Development Control  
Ribble Valley Borough Council

Your ref: 24.0613  
Our ref: D3.24.0613  
Date: 19<sup>th</sup> September 2024

**App no: 24.0613**

**Proposal: Proposed demolition of existing single garage and construction of new single-storey two-bedroom dwelling.(Self build)**

PL.01

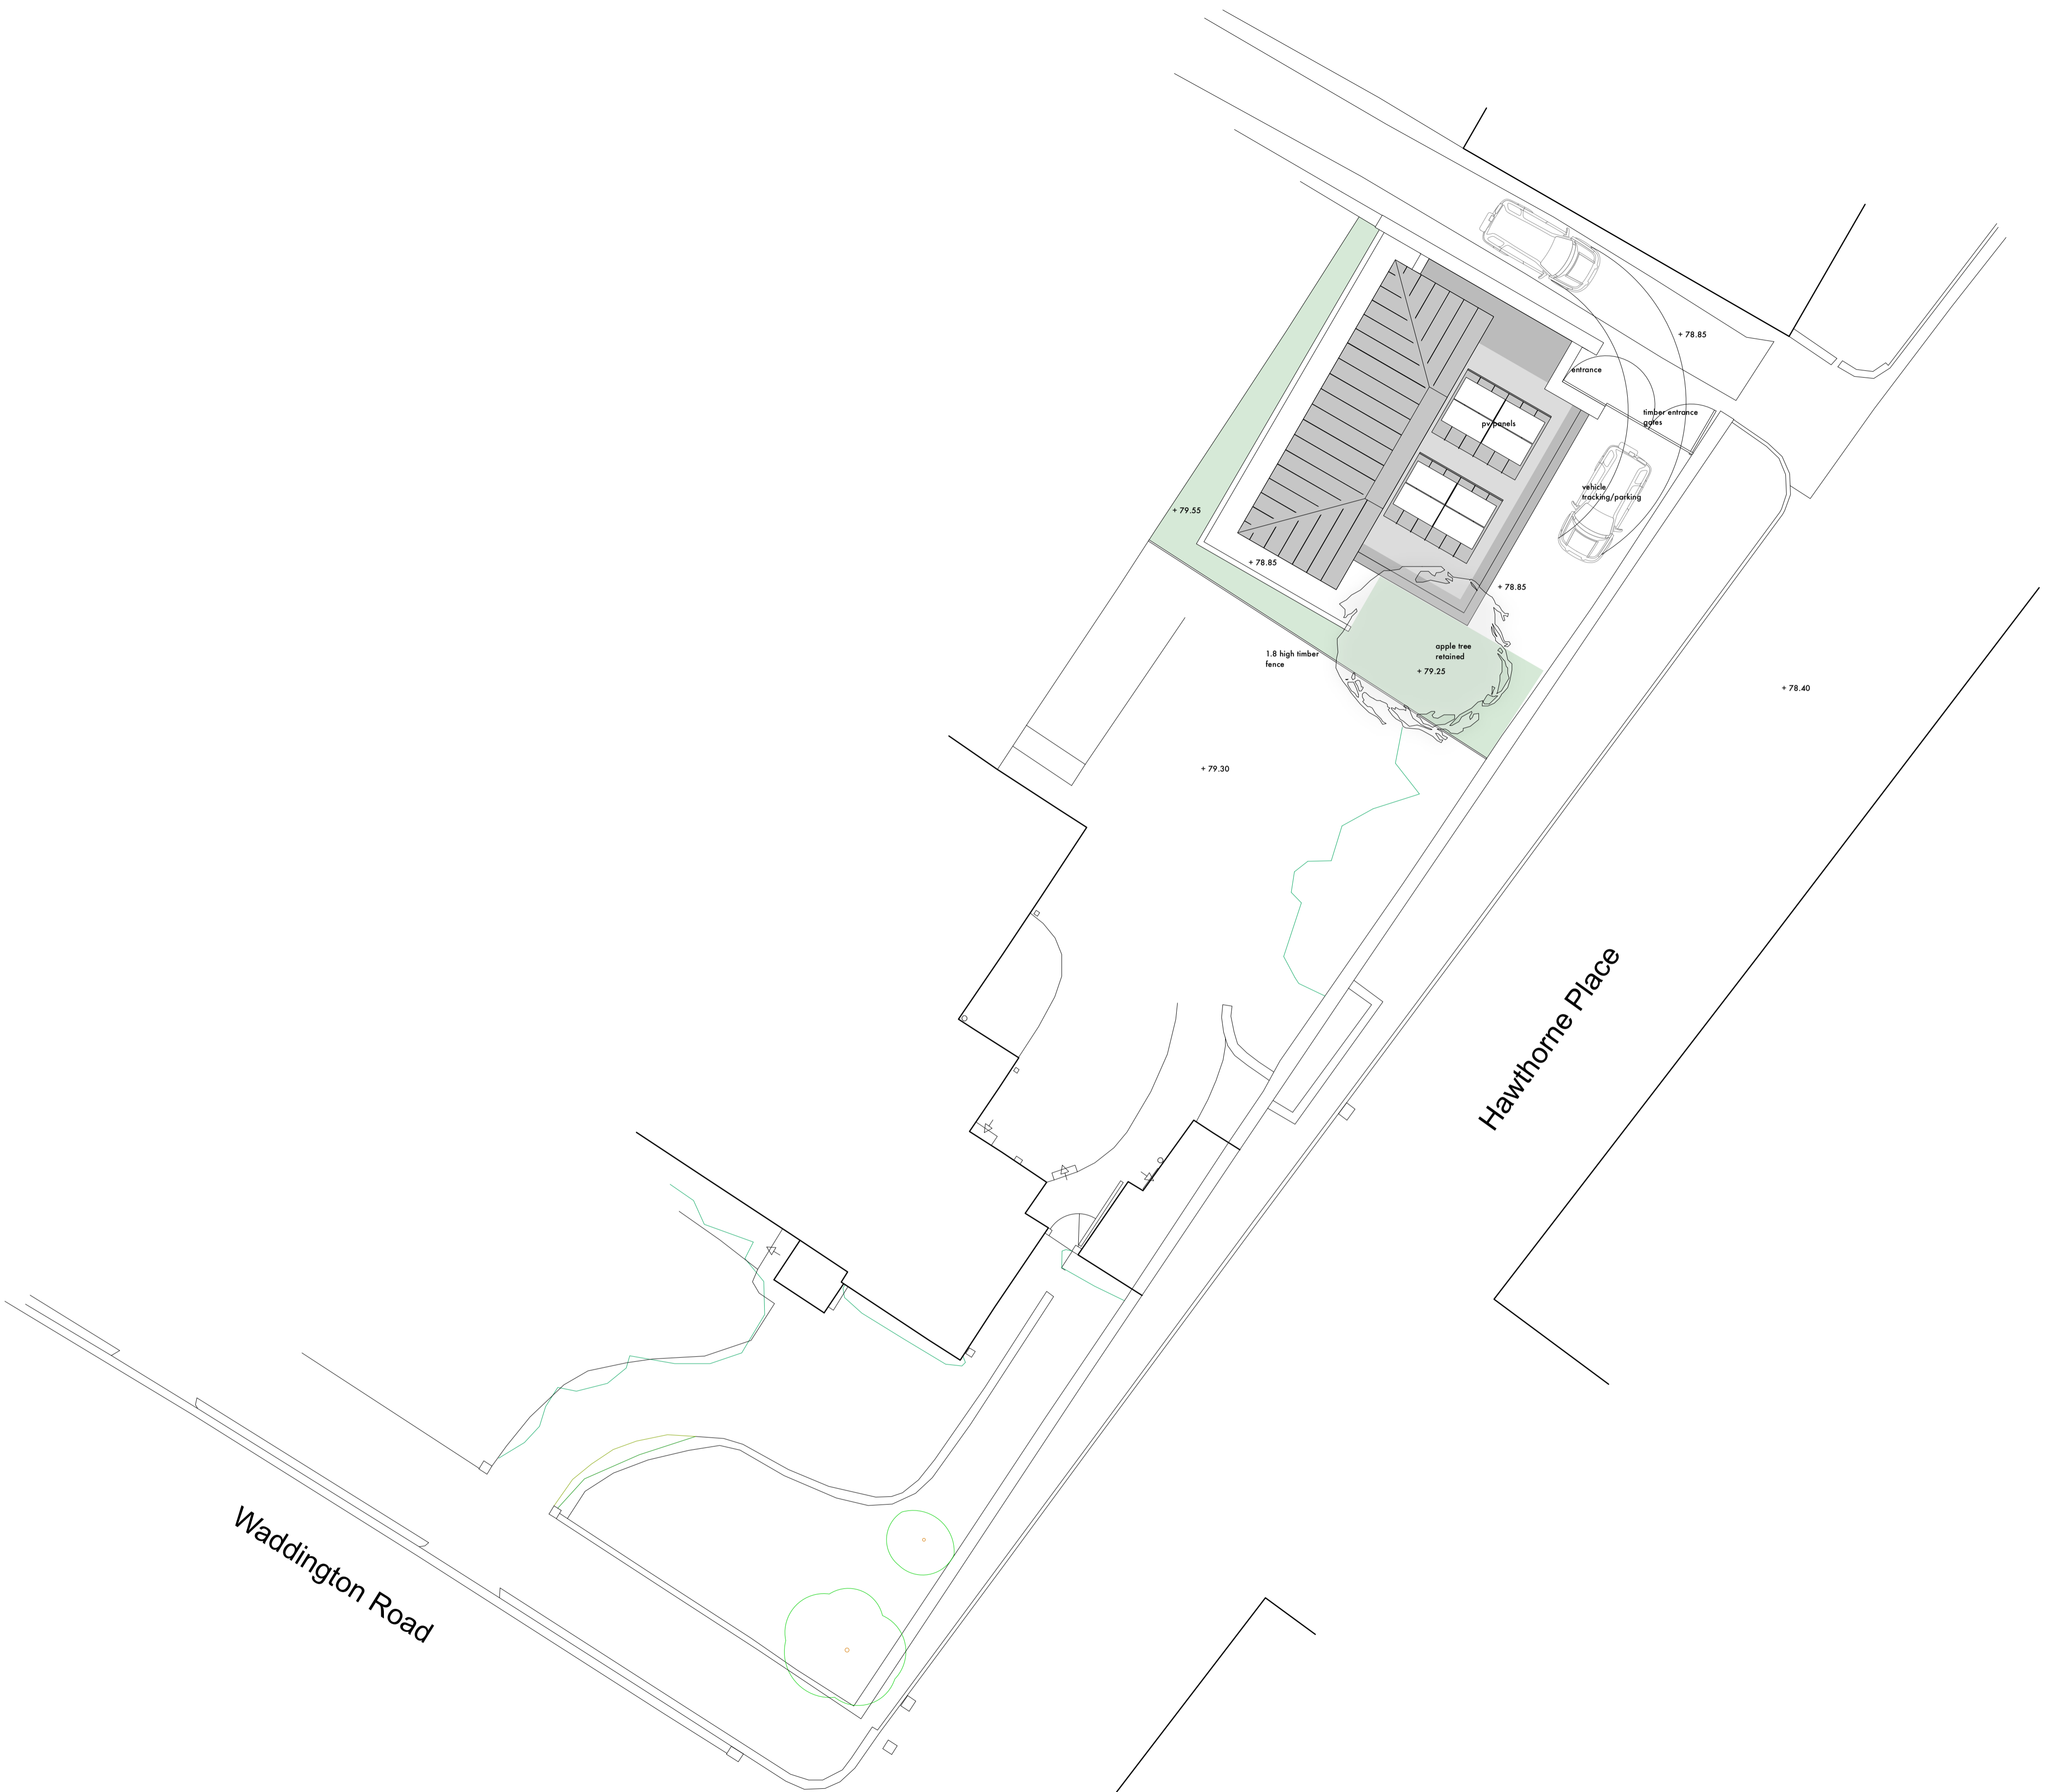
The proposed access uses an existing garage access. The proposed dwelling will result in an intensification of use. The access is constrained and has poor visibility due to the high boundary wall adjacent to the highway and back street. The drivers will be required to undertake multiple reverse manoeuvres to and from Waddington Road which is not supported by the Highway Authority.

When visiting the site it was noted that the back street is used as a pedestrian route and refuse bins are stored there which both cause conflict with the constrained access position.

There are no changes proposed to the boundary treatment therefore visibility for drivers manoeuvring at the driveway is very restricted and conflict with pedestrians is high.

The current application proposes to provide a driveway measuring approximately 9.5m long by 3.75m wide which will provide a single off-road parking space (2 small spaces) accessed from the existing garage access on the back street.

The driveway must be paved in a porous bound material.

Secure and covered cycle parking is required to be provided.
